Sent: 15 August 2012 17:05
To: Planning
Subject: Planning application S6/2012/1135/AD - The Hatfield Arms

Location
The Hatfield Arms
54 Great North Road
Hatfield

Proposal
Installation of 1 x illuminated hanging sign, 2 x amenity signs and 4 x sets of illuminated individual letters

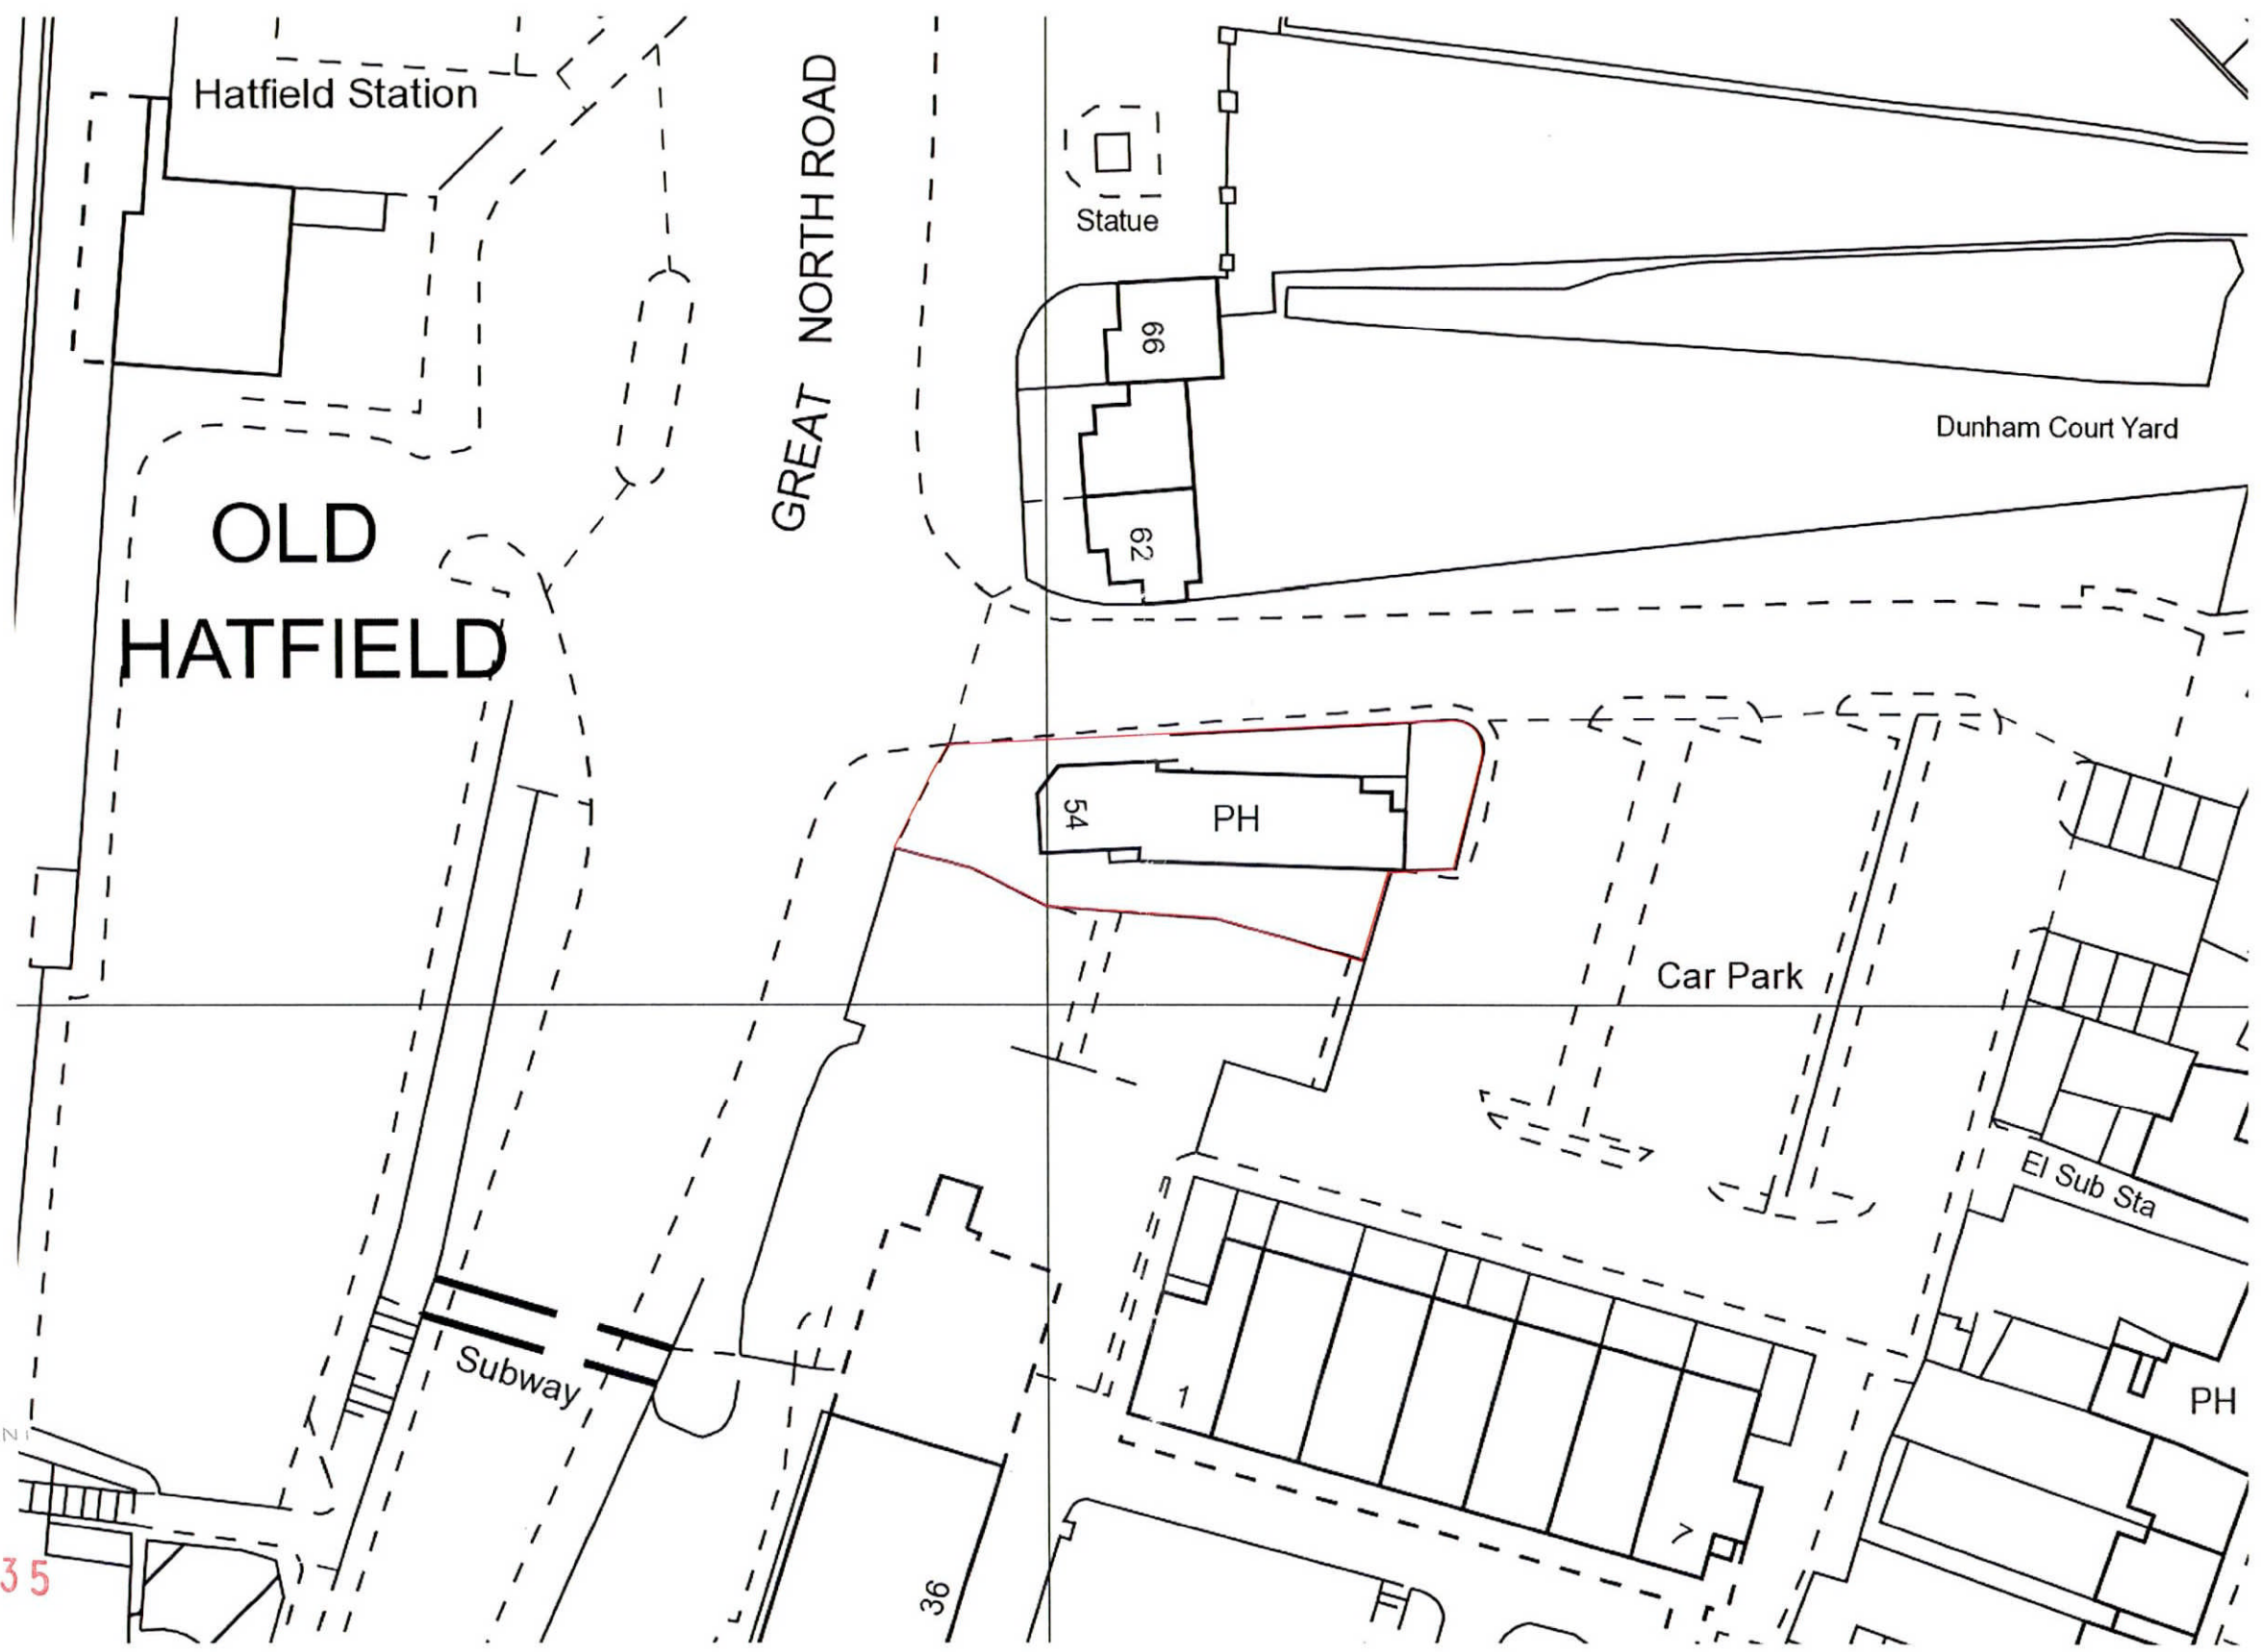
1 The means of illumination shall be shielded so that no glare or dazzle occurs to drivers of vehicles using the public highway. Reason: To avoid glare or undue distraction to road users in the interest of road safety.

Comments: This application for replacement signage and lighting at this public house has no implication on highway safety and as shown on the submitted plan does not affect the free passage of pedestrians.
